Addendum 03

Regarding: **Logan Place SRO Apartment – Bidding Documents**

Subject: **Addendum 03**

The following addendum items apply to the project known as the **Logan Place** located in Portland, Maine.

**D BUILDING SECTION**  
SCALE: 1/4" = 1'-0"

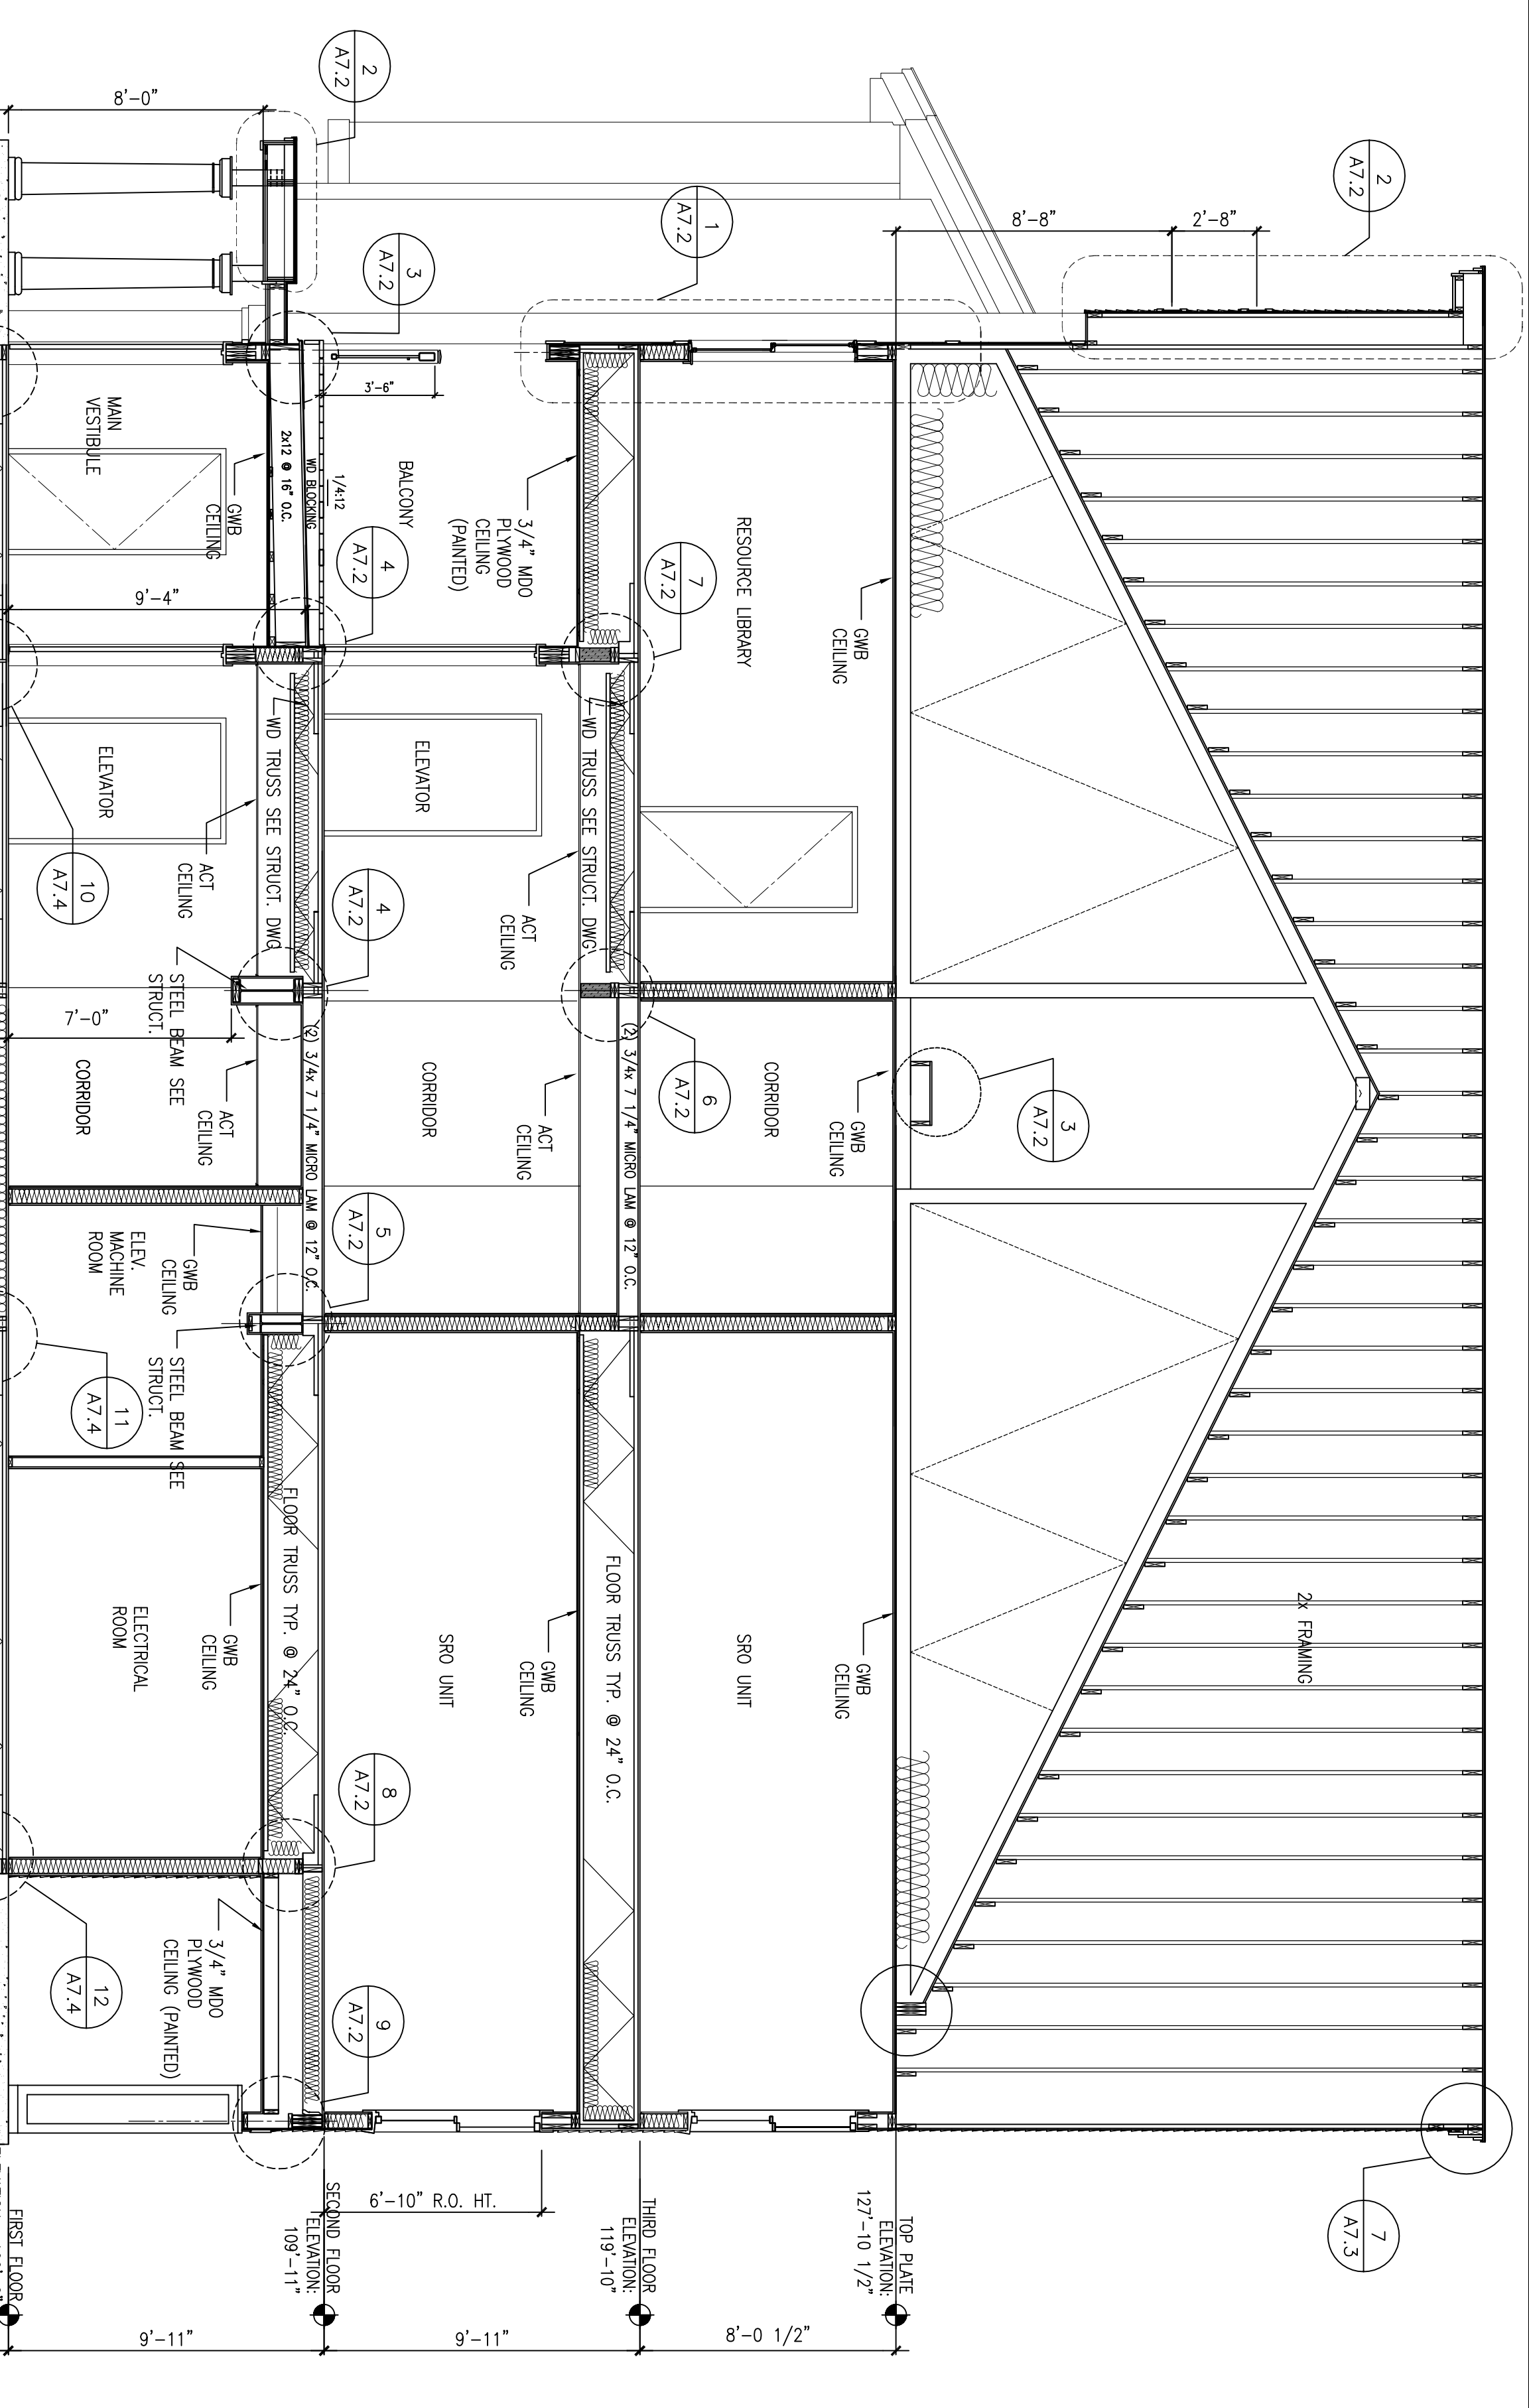
5. Drawing S1.2: Delete structural first floor framing in Mechanical Room [114] as indicated in Building Section D/A5.2.
6. Provide a steel angle L6x3 1/2x3/8 (LLV) on four sides of the masonry chimney to support the 4" brick veneer shown in detail 2/A6.1. Bolt the angle to the 8" grouted CMU with (4) 3/4" diameter threaded rods equally spaced using the Rawl Power-Fast anchoring system (embed bolts 6" min). The angles shall be level and continuous on all four sides off the chimney. Locate the top of the outstanding leg of the angle on the East and West sides at the same elevation as the North side. Brick shall run below the roof sheathing and flashed as shown in detail 3/A6.1.

9. Drawing A5.1 – Building Section A, and drawing A5.2 – Building Section D: Modify 2x8 @ 16" O.C. in Corridor to 2x8 @ 24" O.C.
10. Drawing A7.2: Modify Detail 3/A7.2 to be the same as Section 16 on drawing S3.2.
